**MODIFICATION REQUEST:
MP10_0016 MOD 3**

***Scottish Hospital Seniors Housing and
Care Facility***

Environmental Assessment Report
Section 75W of the *Environmental Planning and
Assessment Act 1979*

May 2017

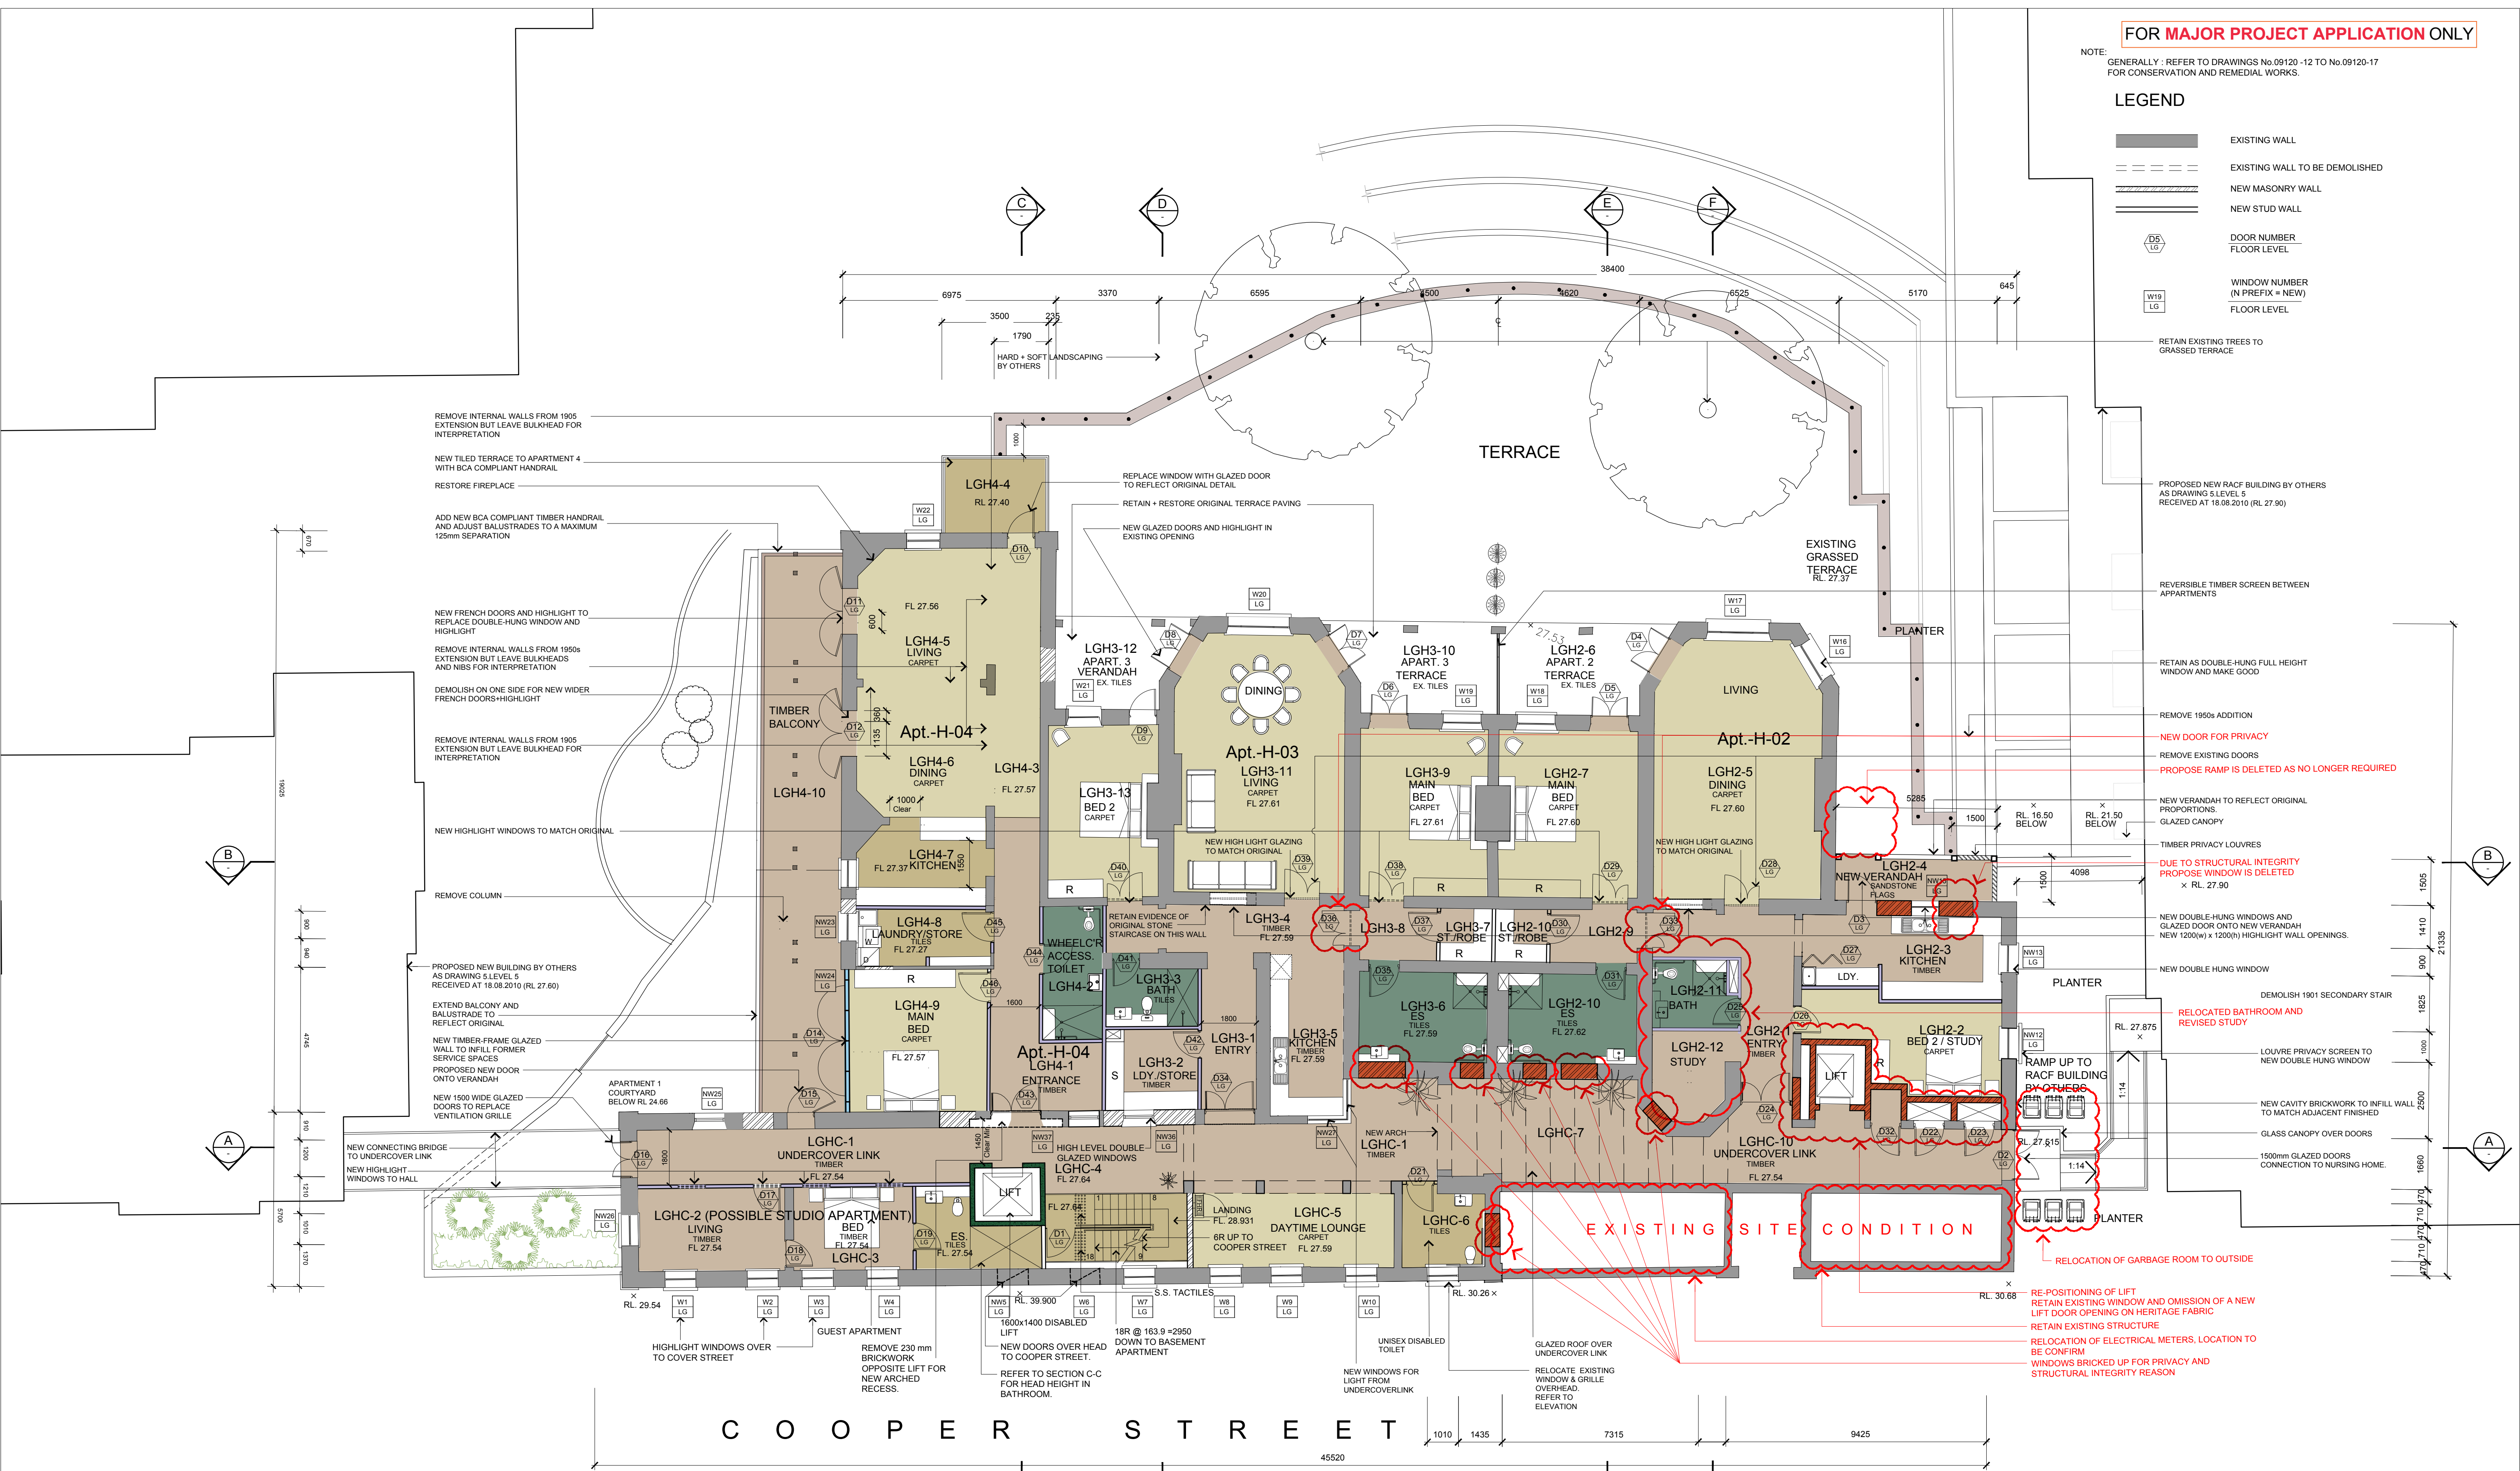
The Proponent is seeking to relocate the garbage bin store from within the building to an external location to the east of the building (**Figure 3**). The Proponent contends that the garbage bin store must be relocated as recent investigations have identified that the current approved location of the bin store is not structurally stable, and requires additional underpinning.

All three public submissions raised concerns about the potential adverse impacts of the external garbage bin store on the amenity of the surrounding area, including visual, odour and traffic (garbage collection) impacts. The Department also requested that the Proponent address:

- how the external garbage bin store can be visually screened, while being sympathetic to the architecture of the Scottish Hospital building; and
- design and/or management measures to mitigate amenity impacts of the garbage bin store on neighbouring properties, such as odour.

The Department has carefully considered the proposed relocation of the garbage bin store, having particular regard to the concerns raised in submissions and the Proponent's response to those concerns. The Department supports the relocation of the garbage bin store, subject to the provision of a bin enclosure with roof (Option 2), for the following reasons:

- the timber design of the bin store enclosure is sympathetic to the heritage building. The structure is discreet, can be easily distinguished from the existing fabric and easily reversed should this be required;

- the bin store enclosure is unlikely to result in adverse visual impacts when viewed from Cooper Street and the surrounding properties, and in particular from properties to the south of Cooper Street, as the bin store is located approximately 3m below street level, visually screened by the boundary fence on Cooper Street (**Figure 9**) and views from the east and south east are screened by the approved RACF building;

- the roof will screen the bin store enclosure from the ILUs in the Scottish Hospital building;
- the bin store will not generate any traffic impacts along Cooper Street, noting that the bins will be moved to the main waste store on Brown Street for collection; and

- the proposed roof structure over the bin store area and the removal of bins at least twice weekly will minimise any potential odour impacts.

The Department recommends a condition requiring that the design and materials of the boundary fence in this location provide a suitable visual screen when viewed from Cooper Street.

02 PROPOSED SOUTH ELEVATION COOPER STREET 1:100@A1
OLD 'SCOTTISH HOSPITAL

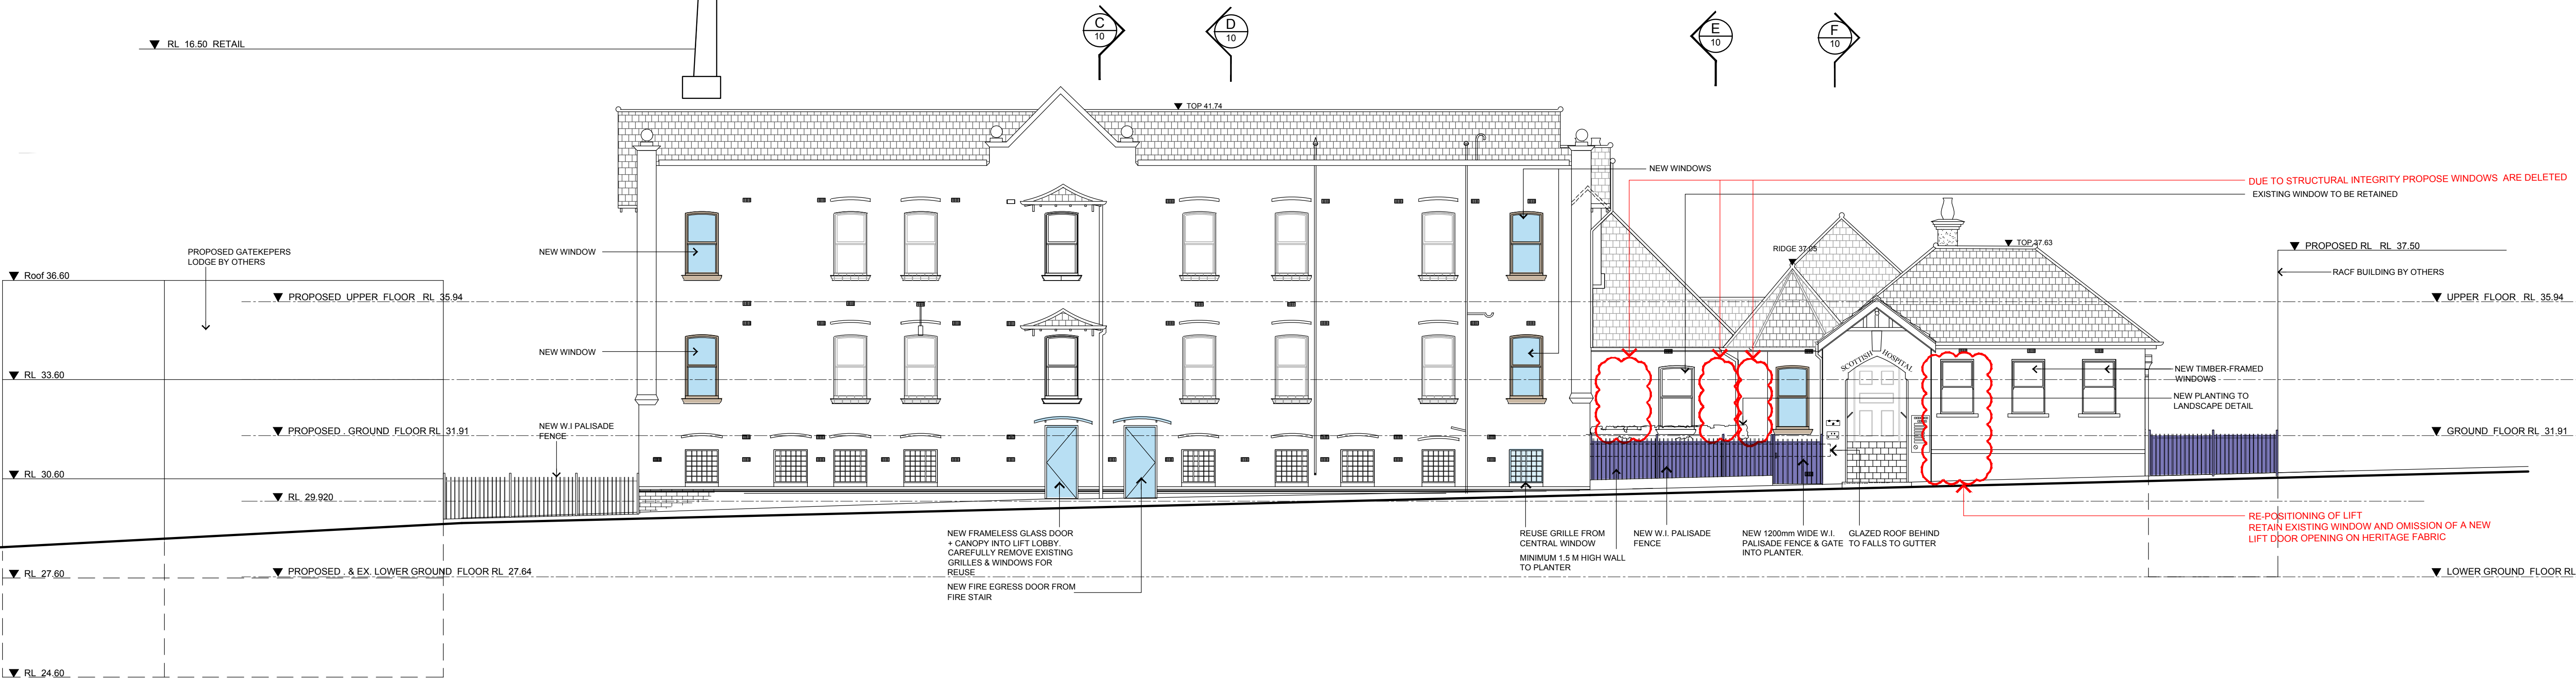
- these windows are not visible from Cooper Street due to the change in levels, undercover link and 1.5m high wall to the planter (**Figure 5**);
- the infill of windows will provide privacy to the bathrooms from the adjoining communal corridor; and

The proposal seeks to infill an existing window (W16 G) in the bay feature on Level 6 facing Cooper Street (**Figure 7**). The Department notes this area is identified in the CMP as having high heritage significance, and that the window is visible from Cooper Street. Noting the visual prominence of this bay feature and window fenestration to the street, the Department recommends that the window be retained. Notwithstanding the structural reasons for infilling the windows, the Proponent has advised that the retention of this window can be achieved.

The Department therefore recommends a condition that amended plans showing the retention of window WG6 on Level 6 be submitted to the satisfaction of the Principal Certifying Authority prior to issue of the relevant Construction Certificate.
